Angmering Parish Council

Angmering Parish Council **OBJECTS** to Planning Applications [REDACTED] A/16/13CA, for 'Proposed demolition of existing Chandlers BMW dealership and Pharers (Sic) Courtledge and erection of 22 dwellings (including 7 affordable dwellings) with associated, car parking, access roads and landscaping.', for the reasons detailed below.

ANGMERING PARISH COUNCIL - [REDACTED] A/16/13CA PLANNING APPLICATIONS FOR HOUSING
ON THE CHANDLERS/BMW SITE IN ANGMERING VILLAGE CENTRE

RGP TRANSPORT PLANNING STATEMENT

Drawing Title
Refuse Vehicle Track

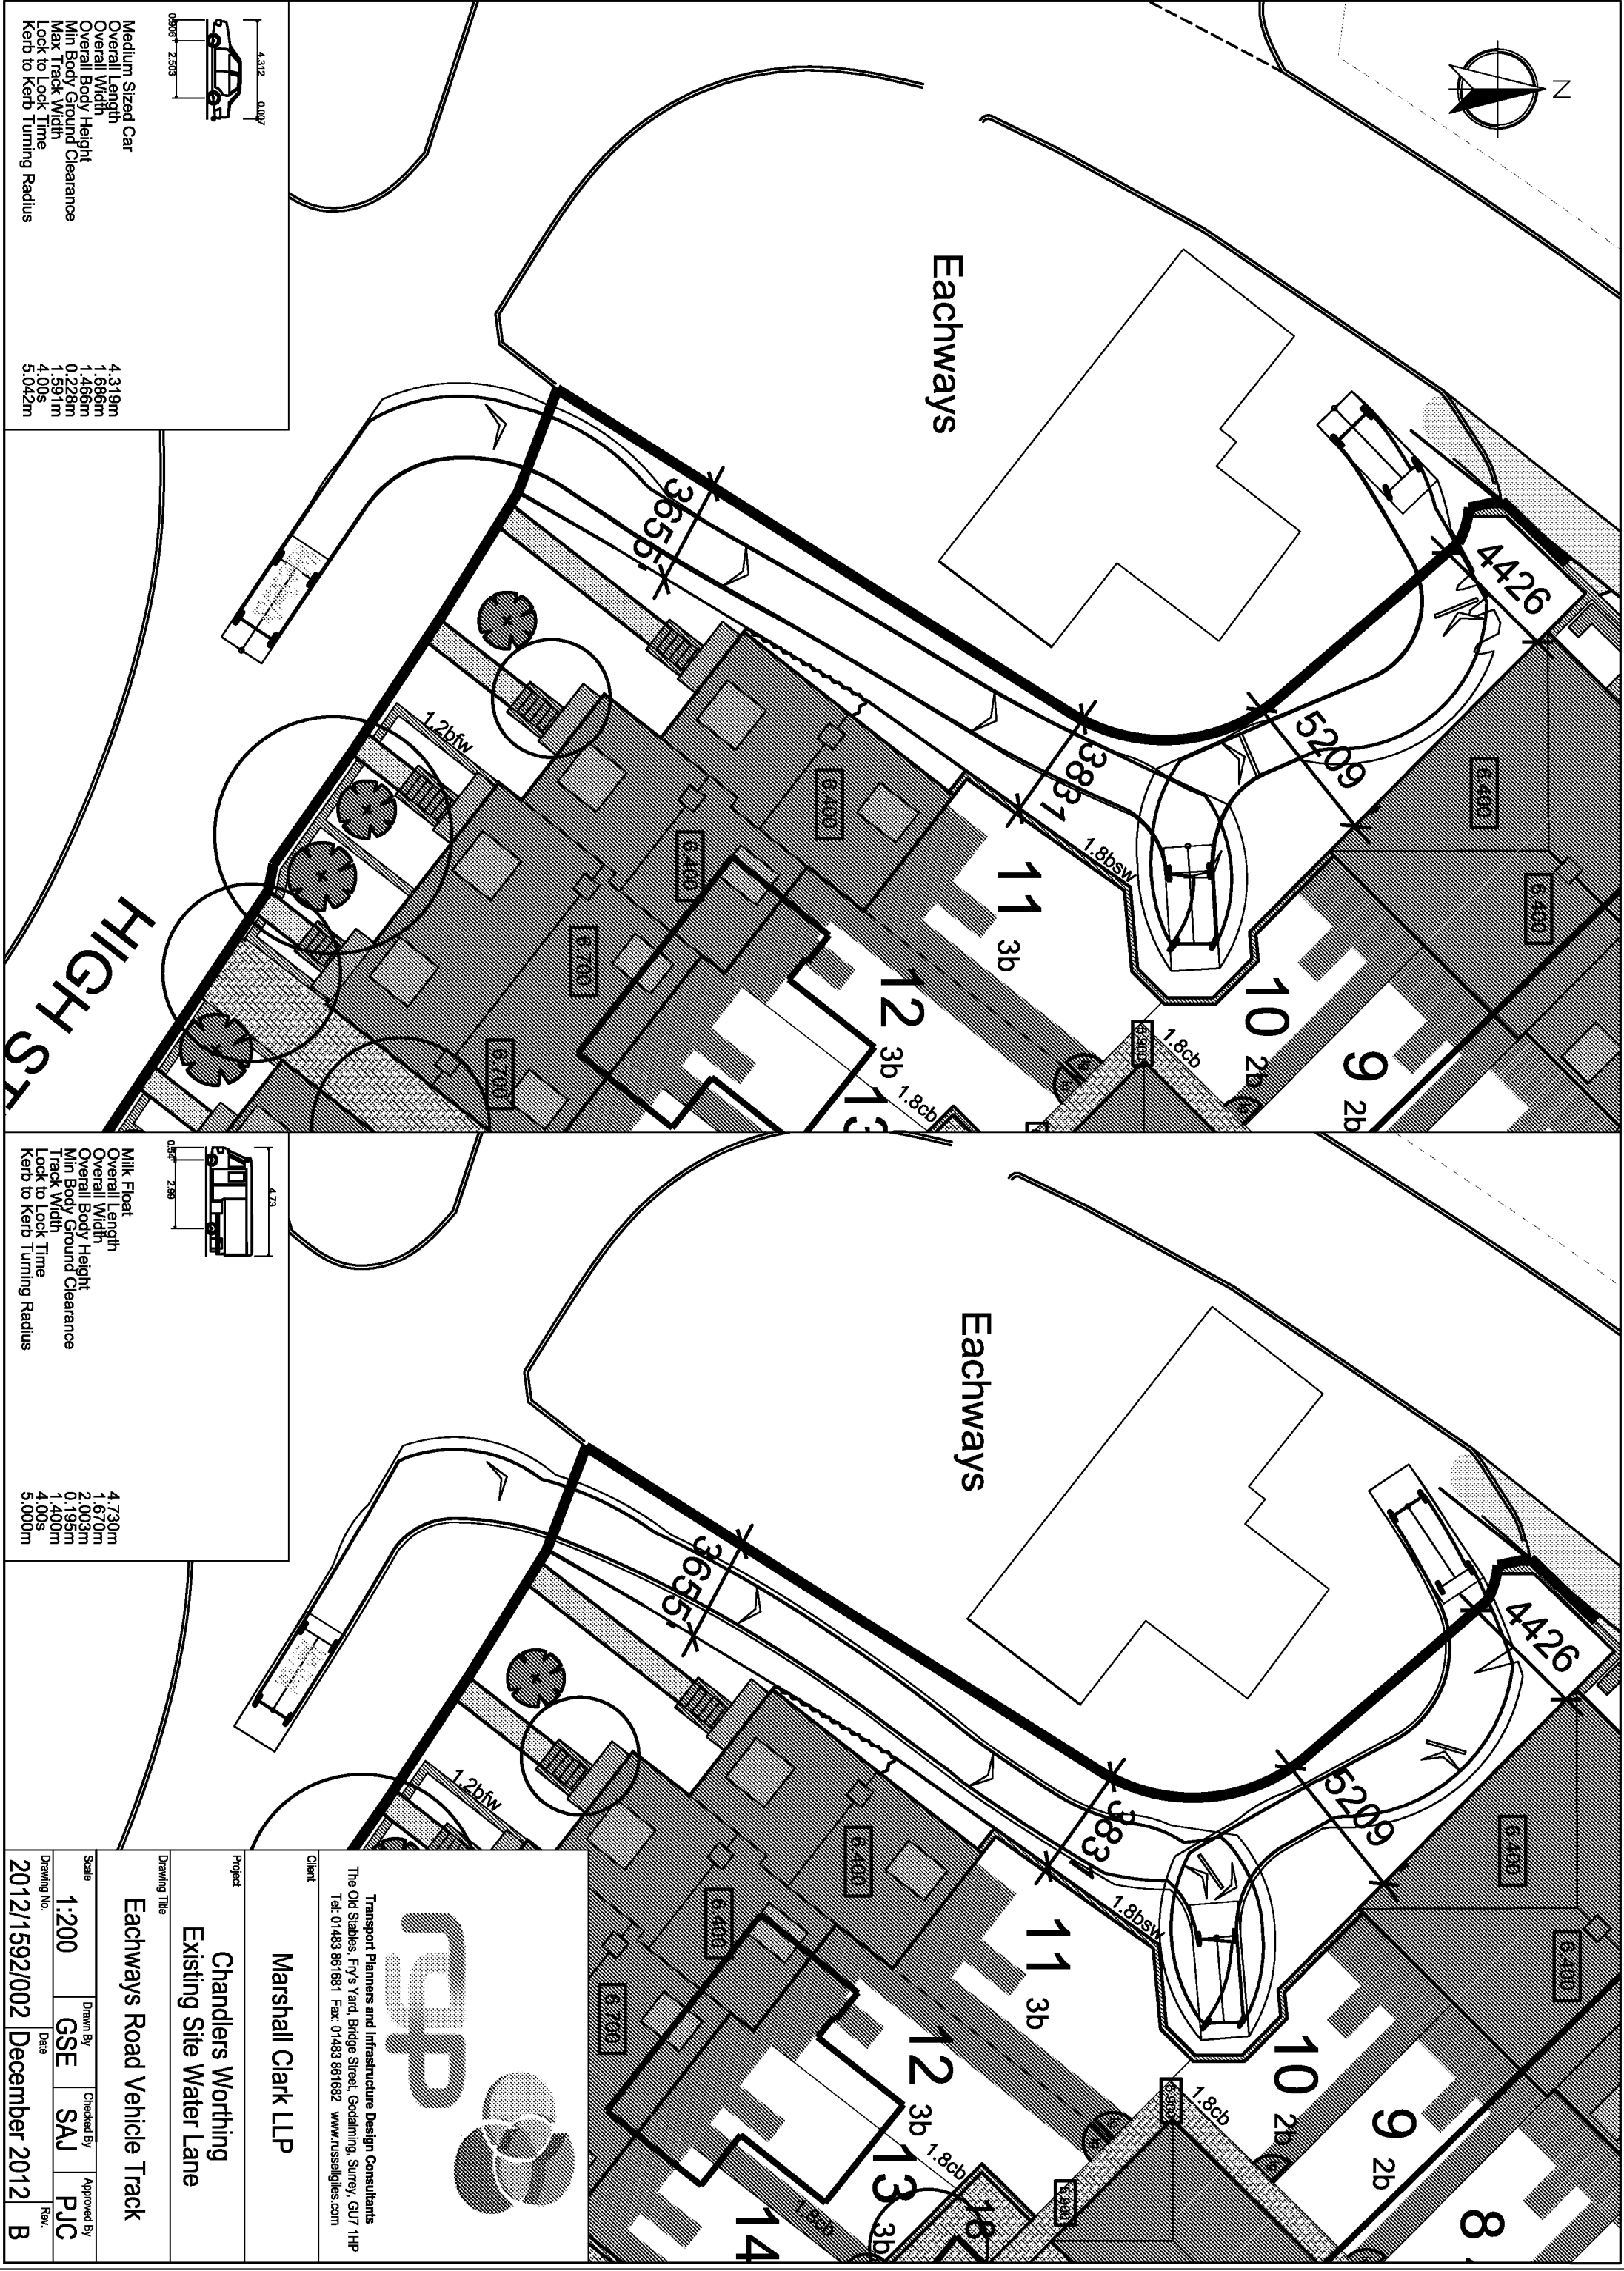
- The supplied information does not adequately demonstrate the site's ability to be accessed by service vehicles, when other vehicles are parked on Water Lane.
